**ADC Planning Consultation
Conservation/Design Officer Response**

Application Number	R/99/17/PL
Address	Rustington Parish Church Hall, 77 The Street, Rustington
Description	Replacement windows to a Building of Special Character in a conservation area
Case Officer	Andrew Wood
Date	20 July 2017

RPCM/105^A

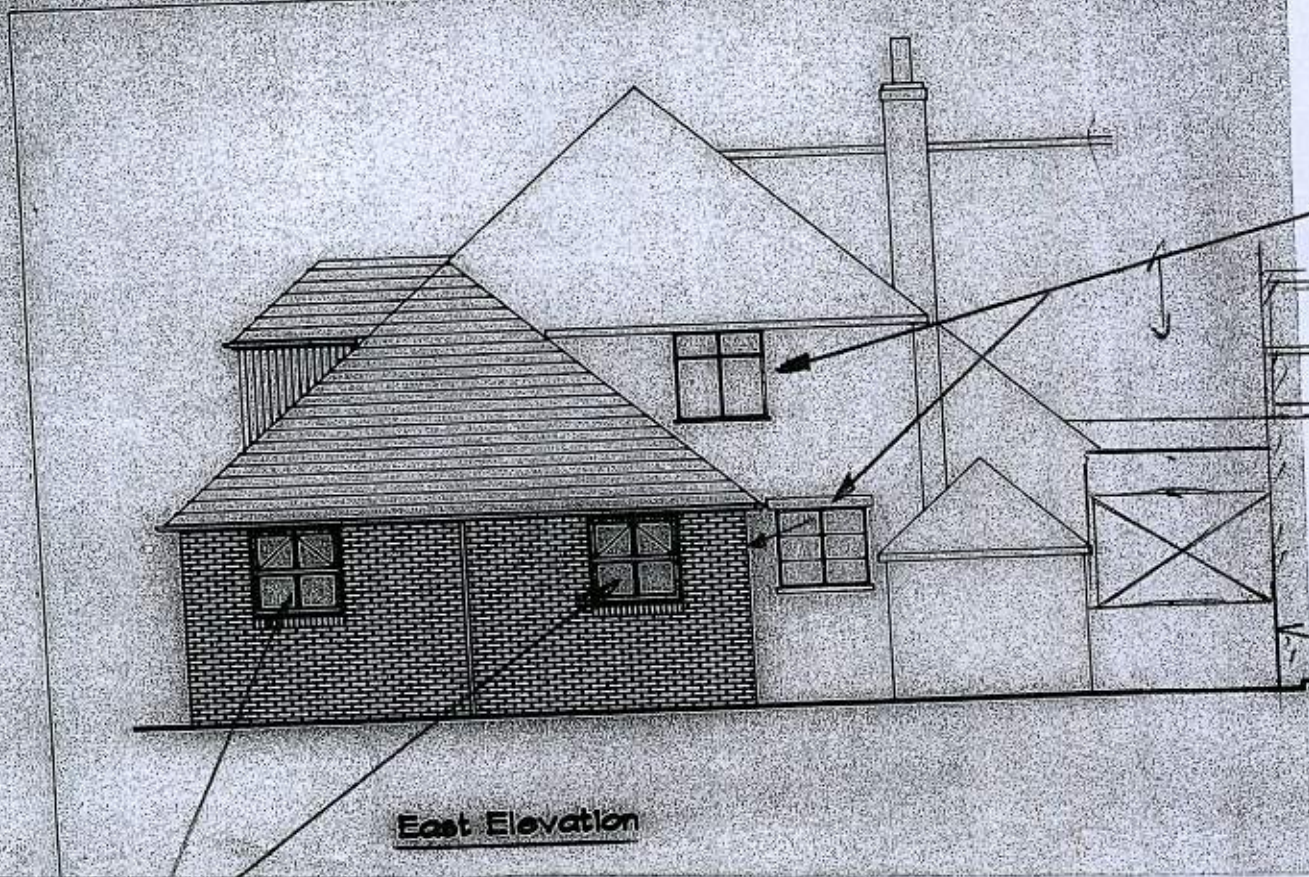
Fenestration is a defining feature of a historic building and the use of UPVC is strongly resisted, as it is a modern 'anywhere' material, devoid of local character and inappropriate to the historic context. In order to preserve the significance of the locally listed building - and maintain its contribution to the special qualities of the designated area - replacement frames must be of comparable materials and similar appearance to the original windows, and thus reasonably consistent with the initial architectural intention. As the replacement windows are discretely located to the side and rear, the inclusion of 'slimline' double glazing within appropriately designed and finished timber frames would be condoned in this instance.

The Church Hall is an important component of the designated area and its distinctive form makes a notable contribution to its special qualities. The proposed replacement windows harm the significance of the locally listed building and harm to a constituent element inevitably diminishes the significance of the conservation area as a whole.

Para. 132 of the NPPF requires great weight to be given to the conservation of designated heritage assets and refusal for the installation of UPVC framed windows is recommended in terms of Local Plan 2003 Policy Area 2, and Local Plan 2014 Policy HER DM2 and 3.
